WEST SUSSEX COUNTY COUNCIL CONSULTATION

TO:	Arun District Council FAO: Anita Gardner
FROM:	Highways, WSCC
DATE:	23/10/2018
LOCATION:	Park View Court, Jubilee Avenue, Rustington, BN16 3ND
SUBJECT:	R/221/18/PL Extension to existing roof to form 2 No. 2 bedroom flats, provision of 3 No. parking spaces & associated works.
DATE OF SITE VISIT:	N/A
RECOMMENDATION:	☒ Advice ☐ Objection ☐ Modification ☐ No Objection ☐ More Information ☐ Refusal
S106 CONTRIBUTION TOTAL:	£N/A

PROPOSED BLOCK PLAN 1:500

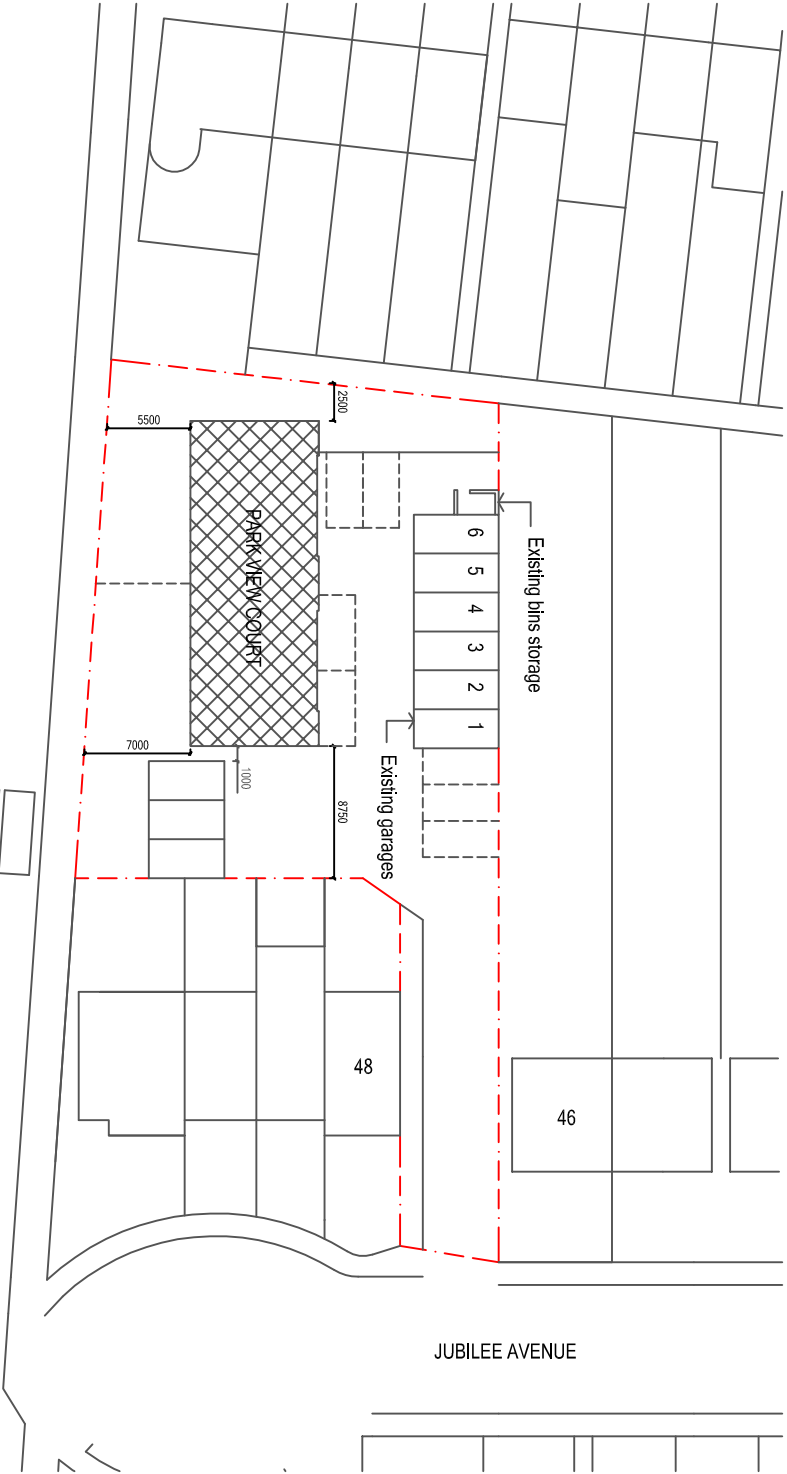
The proposed plans indicate that two of the existing 13 parking spaces will be relocated to form a total of 14 parking spaces, of which three will be allocated to the proposed flats. This will result in the loss of two of the existing parking spaces for the existing flats. Whilst on-street car parking is limited in the immediate vicinity there are comprehensive parking restrictions prohibiting vehicles from parking in places that would be detriment to highway safety. We would not consider that highway safety would be detrimentally affected through the proposed car parking provision. The Planning Authority may wish to consider the potential impacts of this development on on-street car parking.

The plans indicate that two of the three relocated parking spaces do not meet the minimum depth of 4.8m per space. The applicant should increase the depth of these spaces to meet the minimum specifications of 2.4 x 4.8m in accordance with WSCC guidelines. Details of this can be secured via condition.

No part of the development shall be first occupied until the car parking spaces have been constructed in accordance with plans and details to be submitted to and approved in writing by the Local Planning Authority. These spaces shall thereafter be retained at all times for their designated use.
